OXFORDSHIRE COUNTY COUNCIL'S RESPONSE TO CONSULTATION ON THE FOLLOWING DEVELOPMENT PROPOSAL

Application no: 16/02482/REM-2

Proposal: Reserved matters to 13/00433/OUT - Siting, design, external appearance, landscaping, lap, infrastructure, points of access and associated works for 207 new dwellings.

Transport

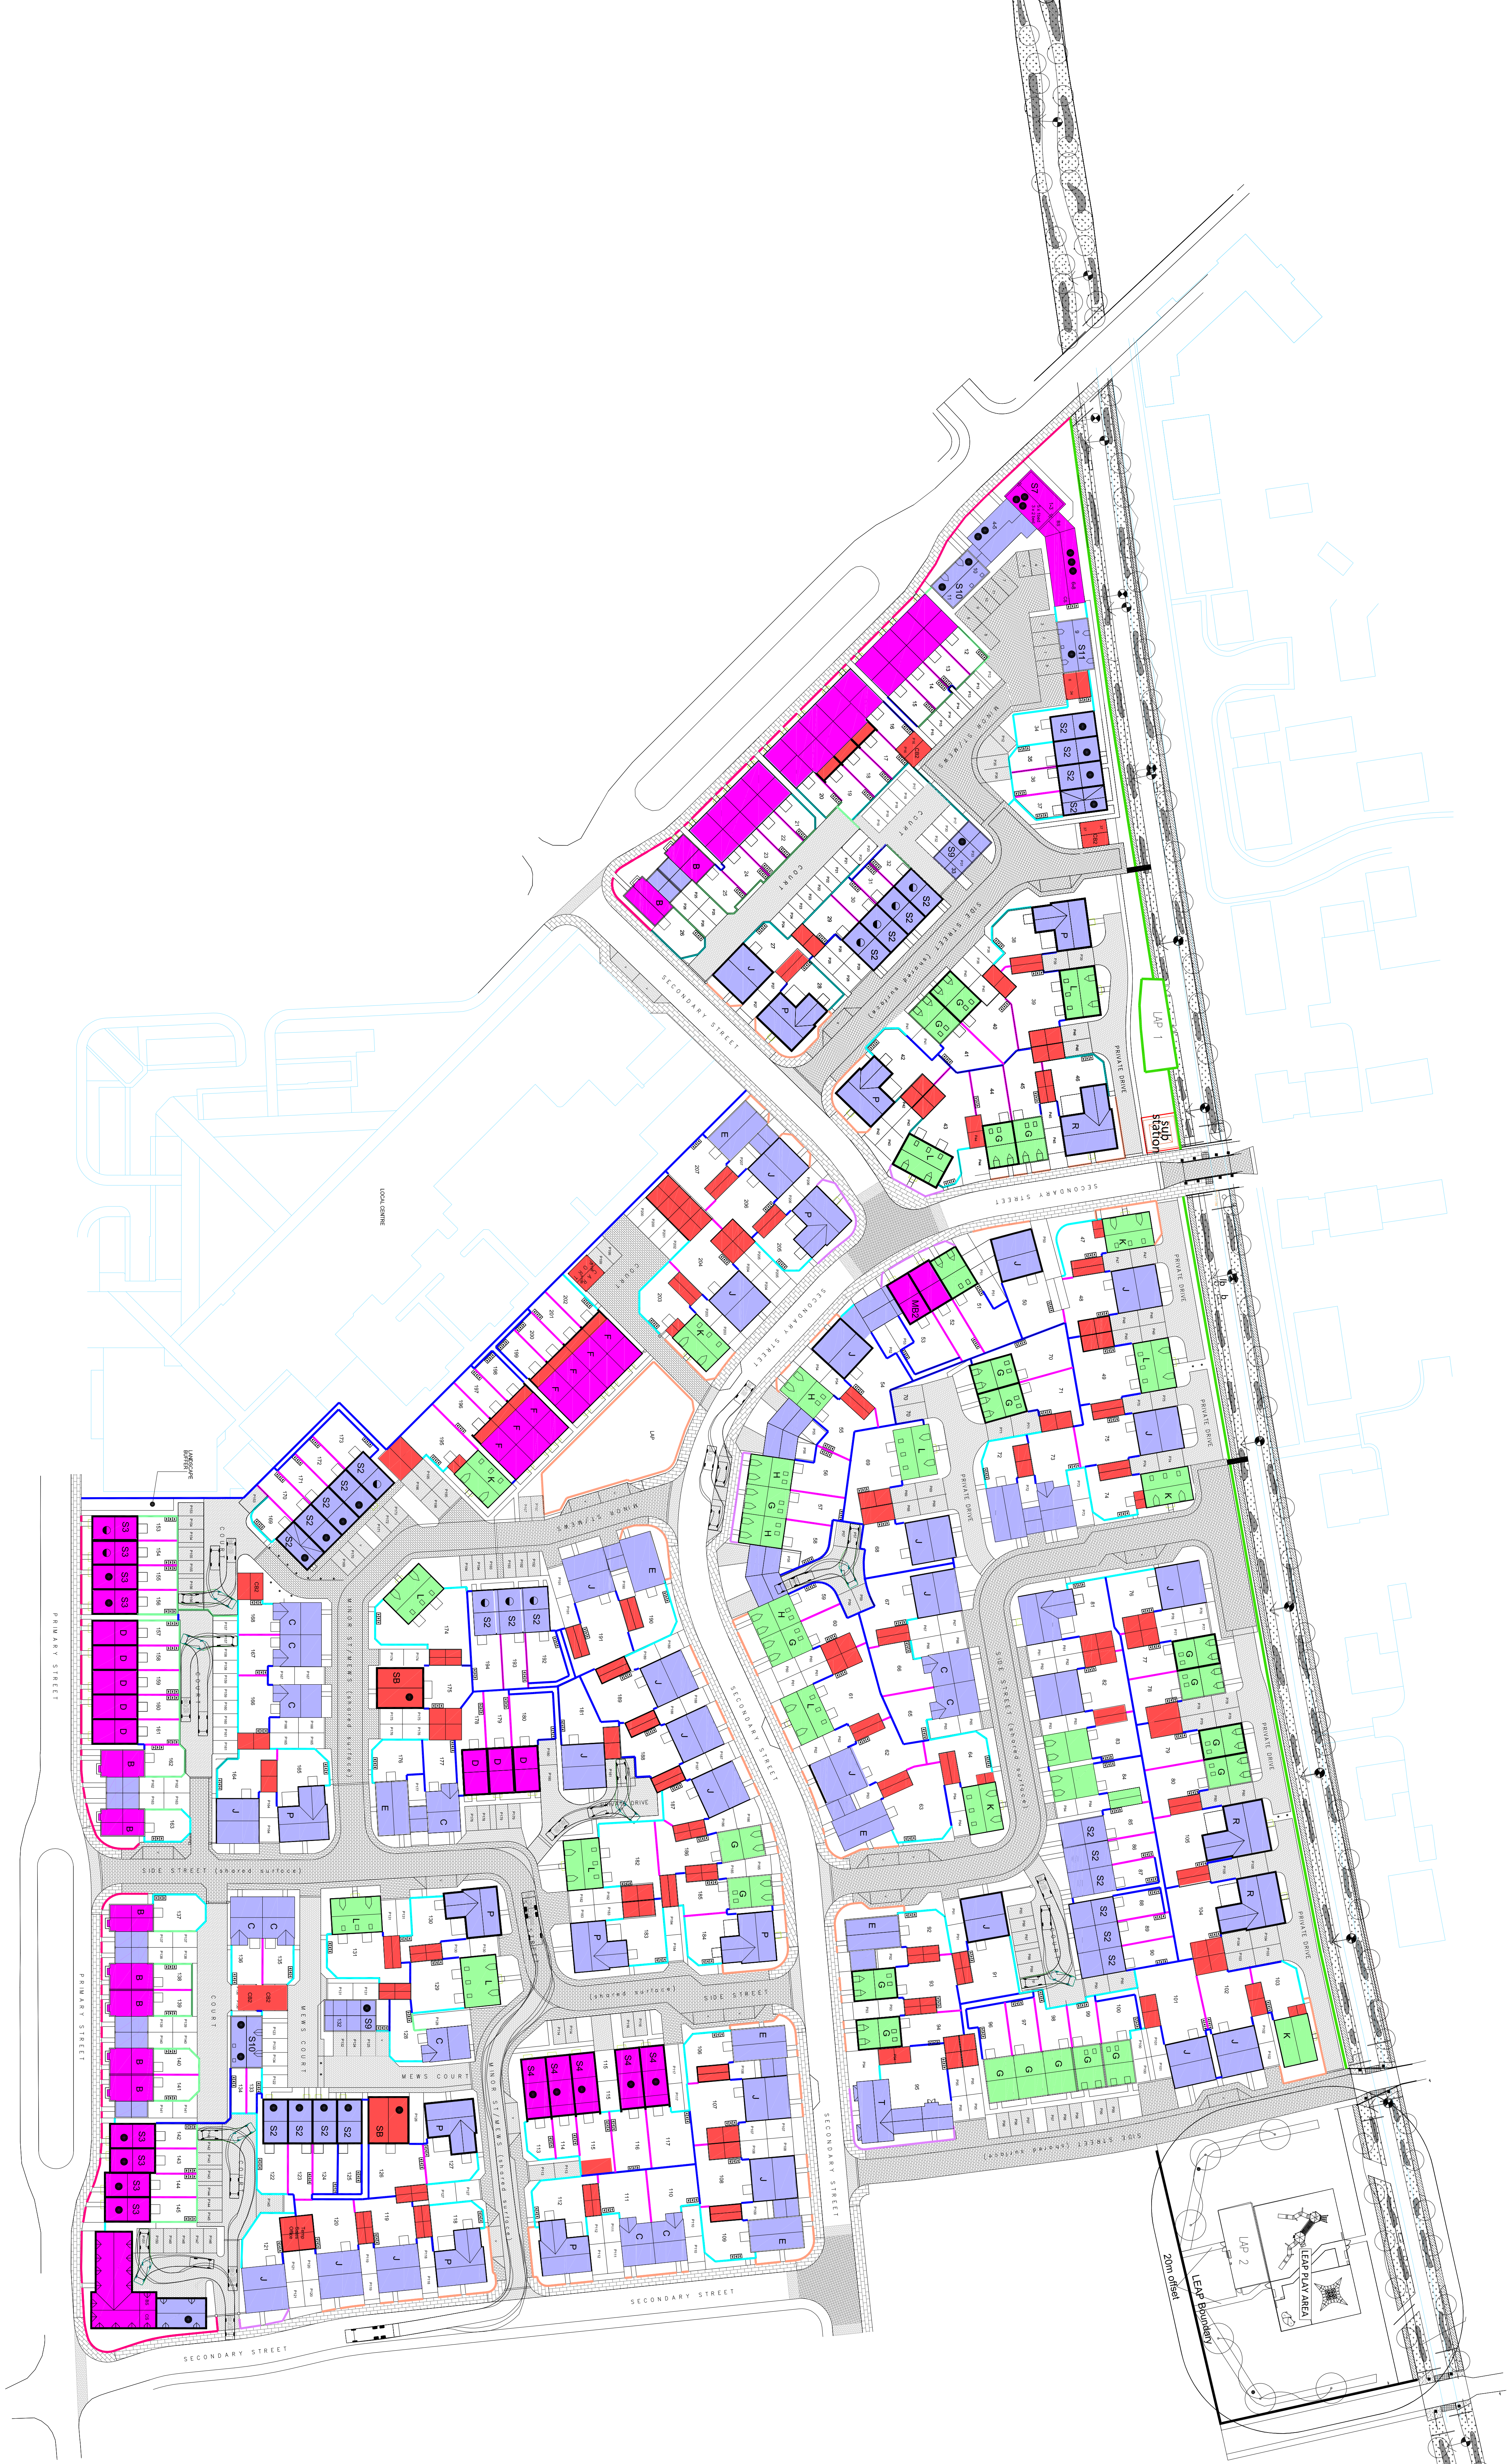
The following is noted in relation to the revised layout as presented on drawing No. **BMKE-02-200 Rev B**.

- Traffic calming has been put in place with build-out chicanes along the secondary street. The applicant should equally consider applying similar traffic calming measures along the Secondary Street and Side Street that run in a north-south direction to the eastern section of the site.

- Having flagged it earlier, hardstanding areas for refuse bin storage appear to be provided within the rear gardens of households. However, a good design should see these run (from cycle sheds for dwellings with sheds) right up to the rear garden access to enable pushing cycles to their storage and dragging of wheelie bins to the bin collection points over a suitable surface.

- Some households with parking allocation within rear courts have now been provided with direct accesses via back gardens.
- A section of shared use carriageway adjacent to plots 34-36 appears to have a width of 5.5m. This needs to be a minimum of 6m wide if the applicant wishes to offer it for adoption as public highway. In the cases of the shared spaces.

It is observed (Drawing Ref: **BMKE-02-200 Rev B**) that the applicant has made significant changes in an attempt to address some key issues that were raised in the previous consultation. A point in reference is the reconfiguration of the rear parking courts which now show that they serve fewer numbers of dwellings as flagged in my previous response.

I appreciate the applicant's endeavour in providing a development that seems conducive to walking, likely to encourage residents not to use their vehicles for shorter journeys. However the revised planning layout does not show good connectivity between footways across carriageways. Crossing points must be shown around appropriate locations to facilitate connectivity for pedestrian and wheeled users throughout the site. Locations such as around junctions of primary and secondary streets should be provided with tactile dropped kerbing for informal crossing.

It has also been noticed that the development has not capitalised on the proximity of the PROW that runs along its northern boundary by making the site more permeable. Bicester policy 12 requires that the development "*is well integrated, with improved, sustainable connections between existing development and new development on this site*" and also that "*new footpaths and cycleways should be provided for that link to existing networks and the wider urban area*". Residents of some households along the northern boundary cannot access the PROW unless they traverse more than 150m to either the secondary street or the side street further east of the site to gain access to the public footpath. I would be happy to see a gap or two for pedestrians to access the footpath as shown in the figure below.

These aspects will need to be amended accordingly and should be shown on a further revised plan.
